From: Anita Gardner
Sent: 02 October 2018 17:04
To: Planning.Responses
Subject: FW: Shell Fontwell ref. WA/71/18/DOC

From: Nick Howard
Sent: 02 October 2018 13:49
To: Anita Gardner
Cc: Fiona Fitzgerald
Subject: RE: Shell Fontwell ref. WA/71/18/DOC

TITLE: BLOCK PLAN as proposed

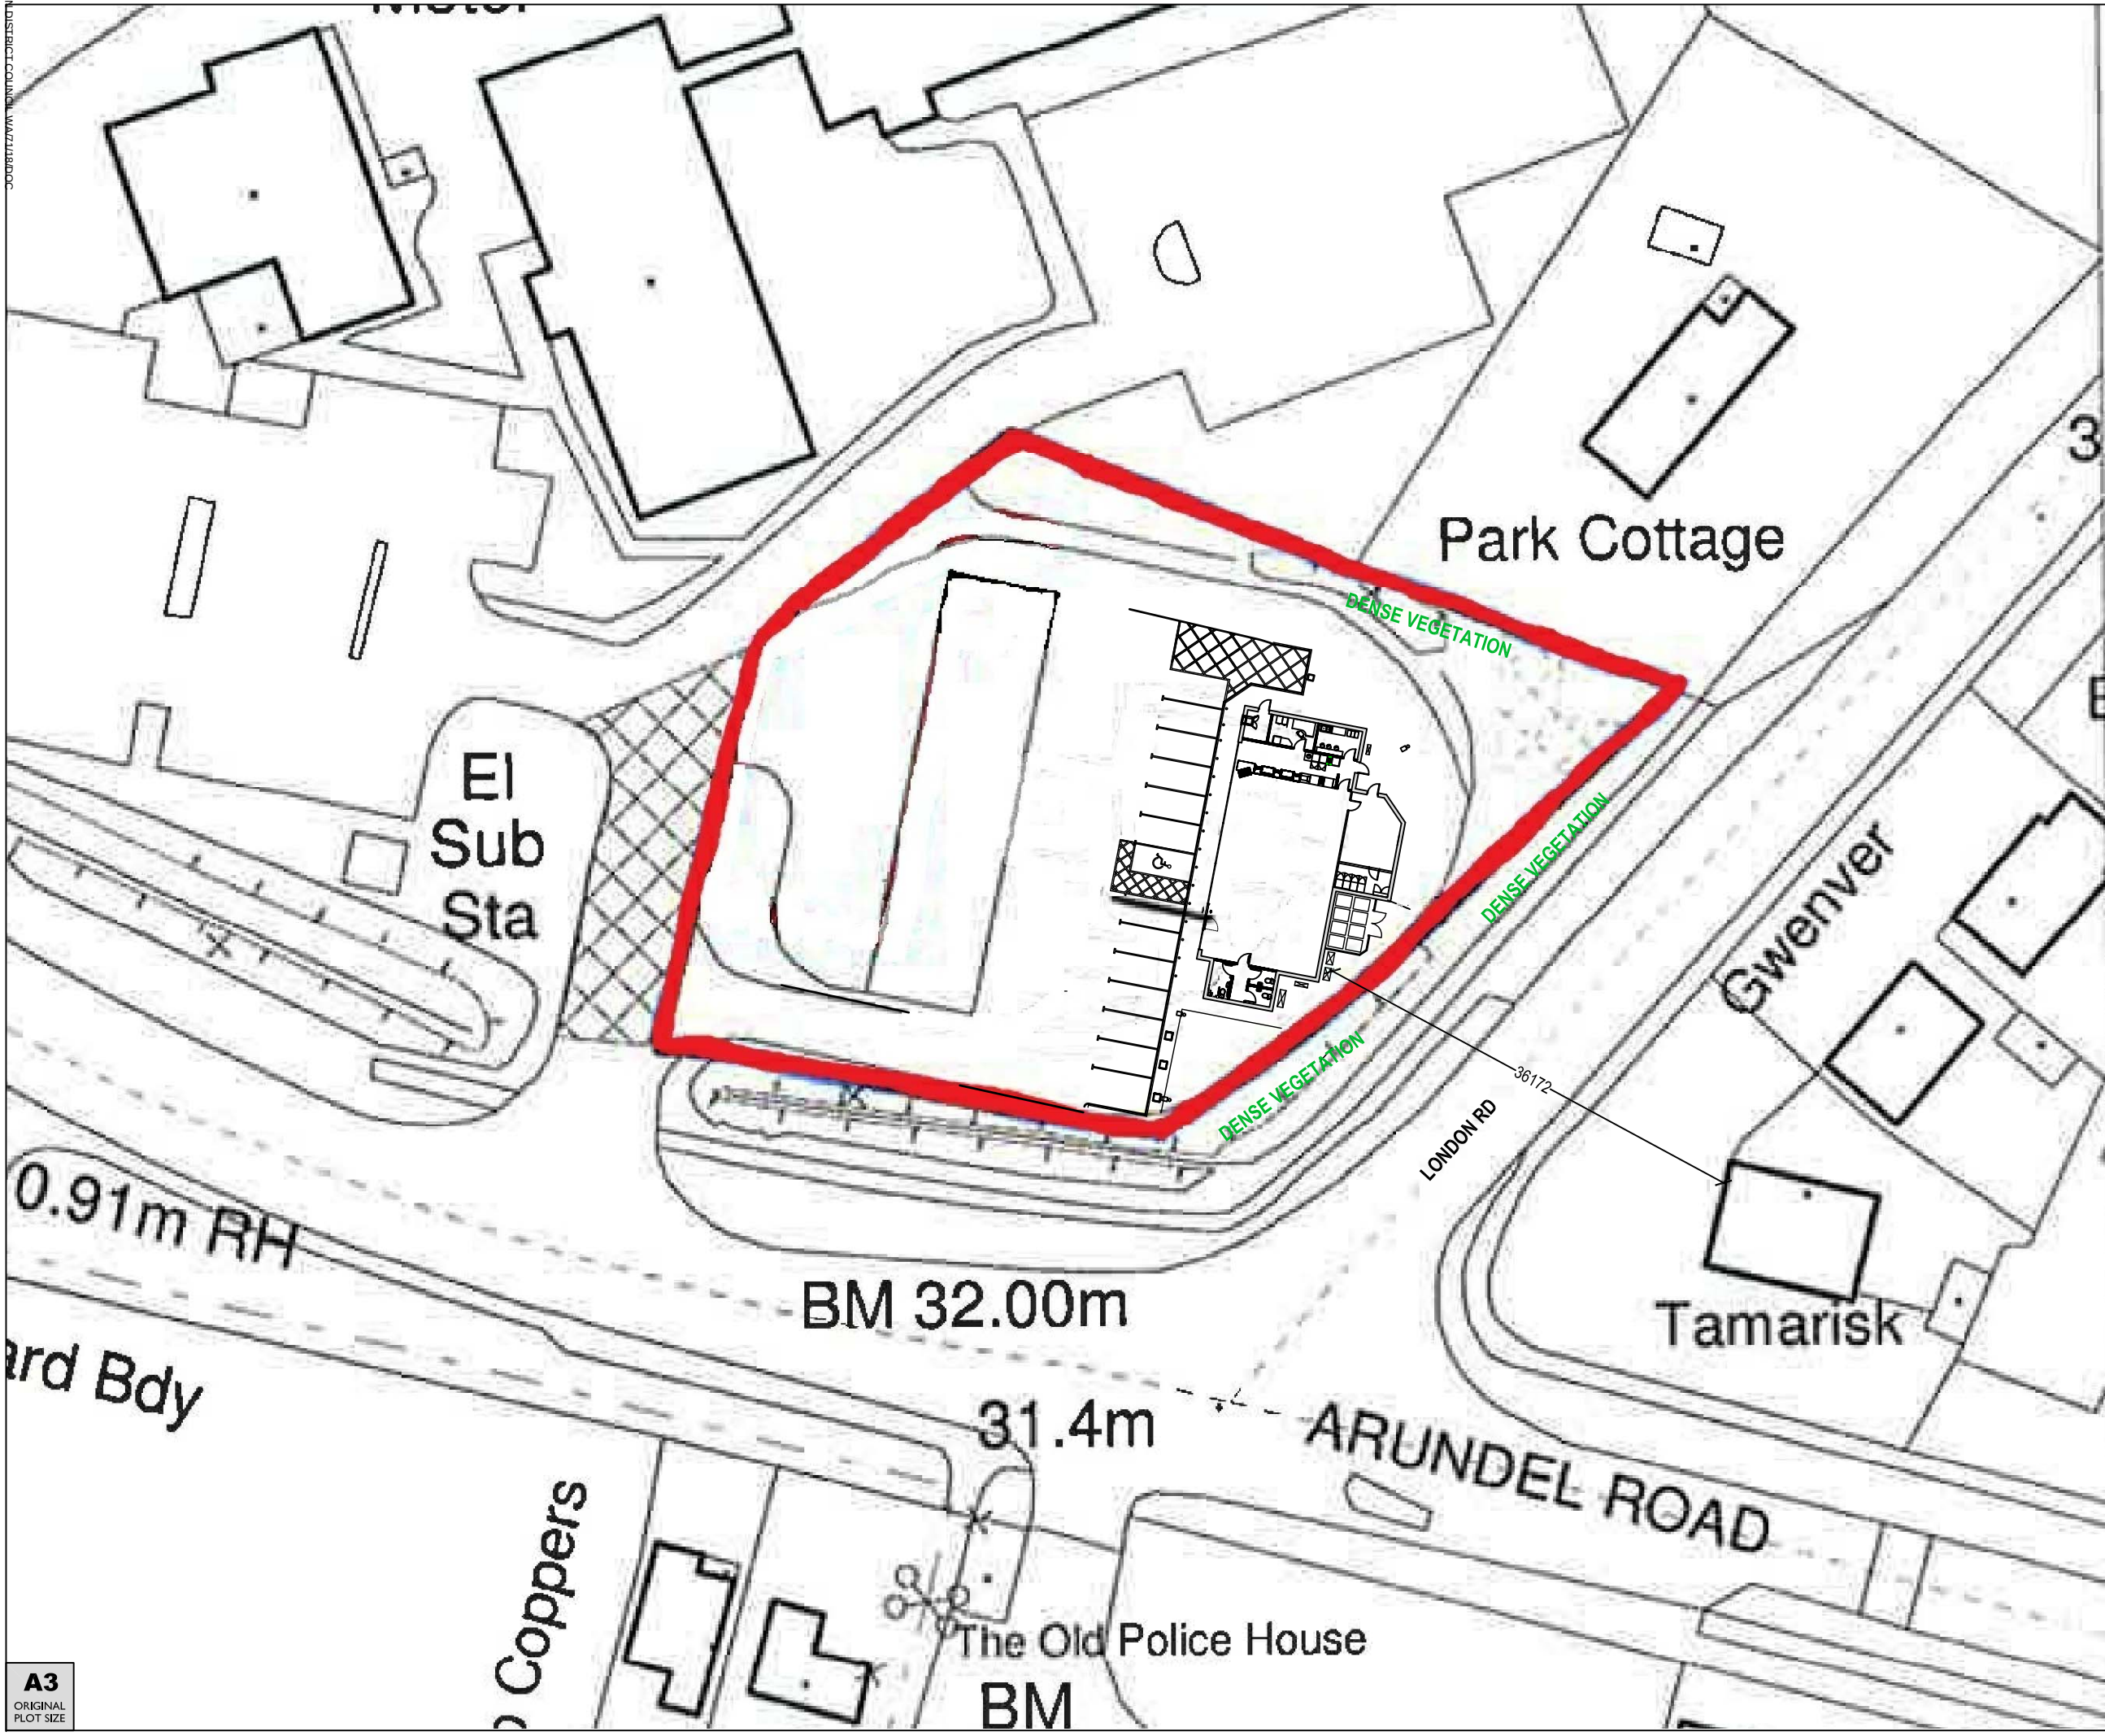
I did receive the original planning consultation. I have looked at the revised documentation and I discussed this case with Fiona. I have concerns over their revised proposal with the building of a noise boundary around the site to help mitigate the noise from the plant machinery and question their Db level reductions from having dense vegetation around the site perimeter. I suggest on having an acoustic housing material around the conditioner units to mitigate the noise generated, to have them properly boxed in would aid compliance with condition No (3).
